Appeal Decision

Appeal Ref: APP/Z4718/W/21/3272237

1 The Copse, Scholes BD19 6NE

- The appeal is made under section 78 of the Town and Country Planning Act 1990 against a refusal to grant planning permission.
 - The appeal is made by Mrs Z Celensu against the decision of Kirklees Metropolitan Council.
 - The application Ref 2020/62/90125/E, dated 8 January 2020, was refused by notice dated 9 February 2021.
 - The development proposed is a detached house within garden.
-

site plan 1:500

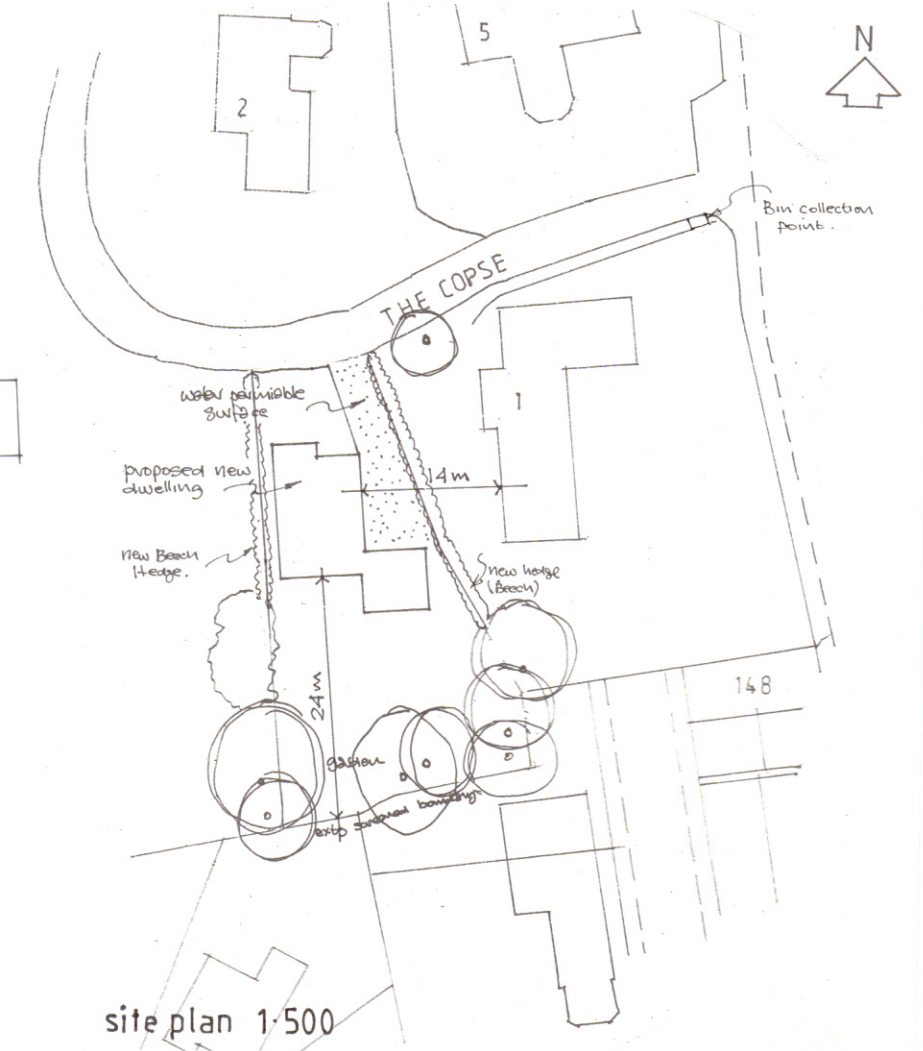
6. Due to the size of the appeal site, the proposed dwelling and its subsequent curtilage, would conflict with the established make-up of The Copse, that being dwellings in spacious plots. In this context it would appear squeezed into the site and out of character with the established formation of the surrounding built environment. Although the design of the dwelling would be compatible with that of the existing dwellings, the resulting intensification would nevertheless cause harm.

**Appendix 8:  
Tree Shadows Plan**

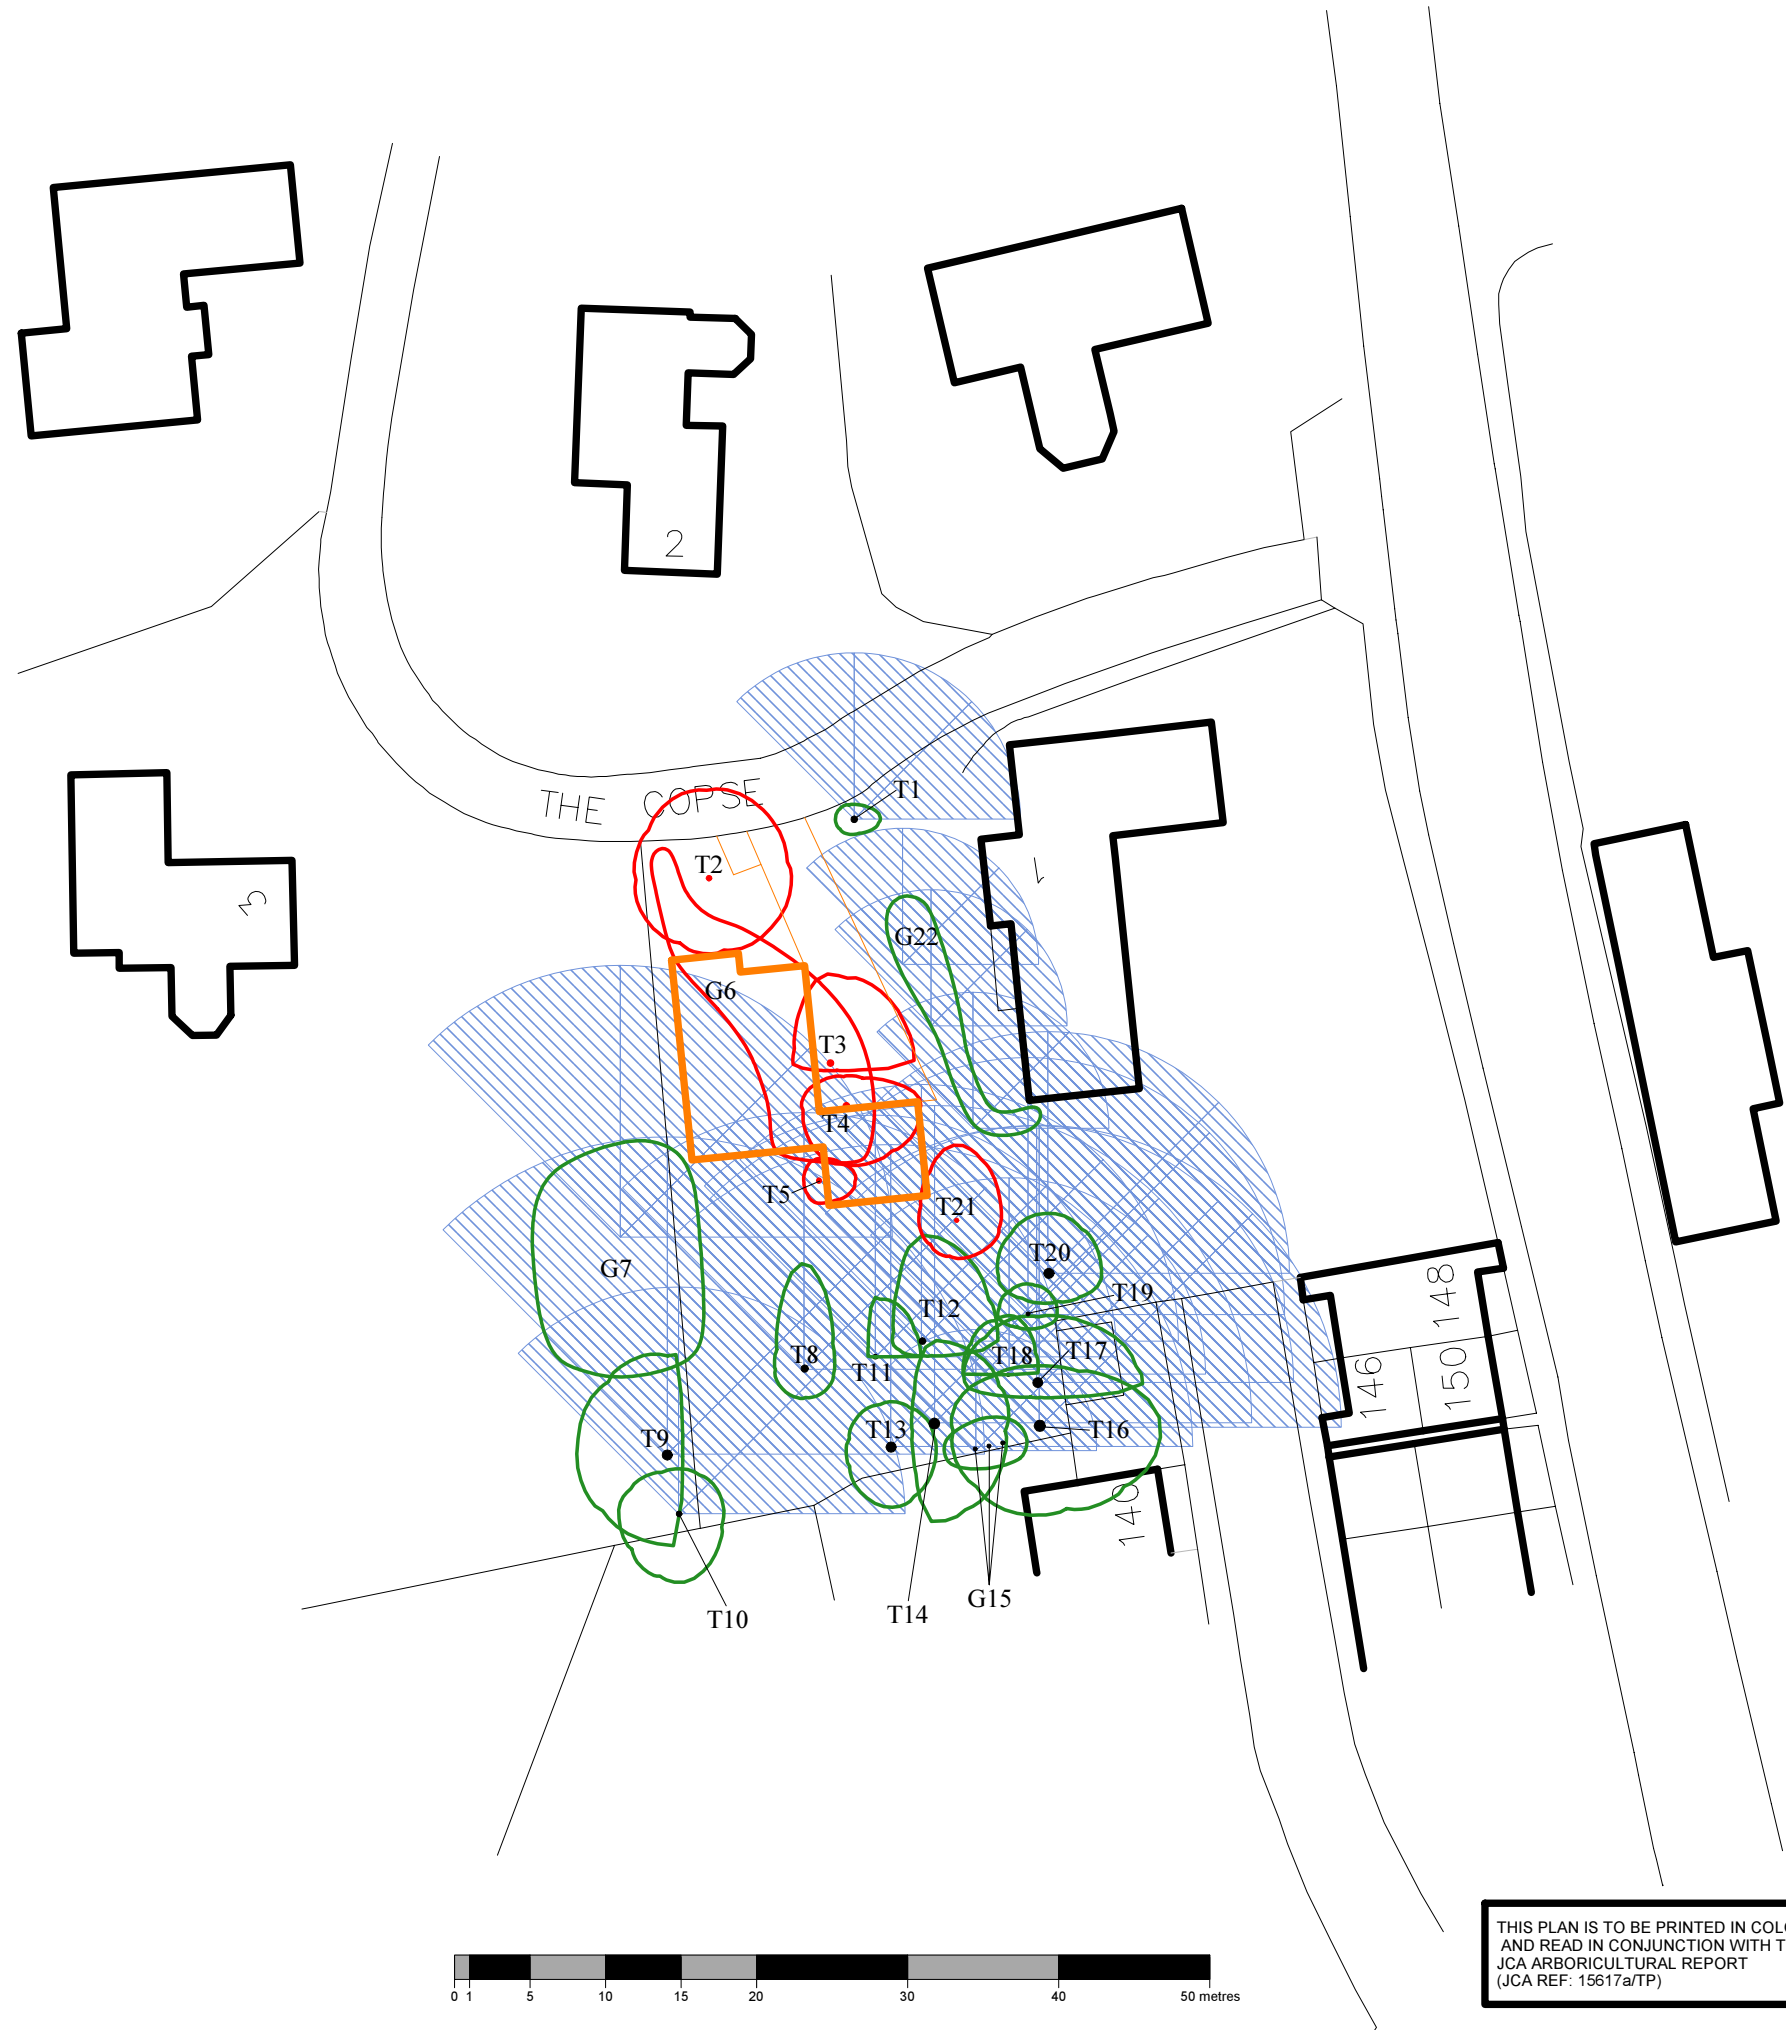
12. The development includes the provision of a rear garden area to serve the proposed dwelling. This would contain the large mature trees that are to be retained on the site. The proposed rear garden would also be directly looked onto from the proposed living/kitchen and bedrooms 1 and 4. During my site visit, that was undertaken around midday on a sunny day in August, I observed that the trees were in full leaf and that the area of the proposed garden was almost in full shade.
13. The garden and the specified rooms would therefore receive limited light as a result of overshadowing from the tree canopies which would give the rear of the dwelling a dark and gloomy character. As demonstrated in the submitted

Tree Shadows Plan, this would be to varying degrees throughout the day. It would also be of varying degrees throughout the year when the sun is lower, and the deciduous trees are not in leaf. Nevertheless, despite this variation, I find that overall, due to the siting of the dwelling in relation to the positioning and massing of the trees that are to be retained, there would be unacceptable living conditions as a result.

17. I therefore conclude that the overshadowing that would be caused from the retained trees would result in unacceptable living conditions for future occupants of the property in terms of light. The proposed development would therefore be contrary to Policy LP24 of the Kirklees Local Plan (2019) which requires, amongst other things, that developments provide a high standard of amenity for future occupiers.
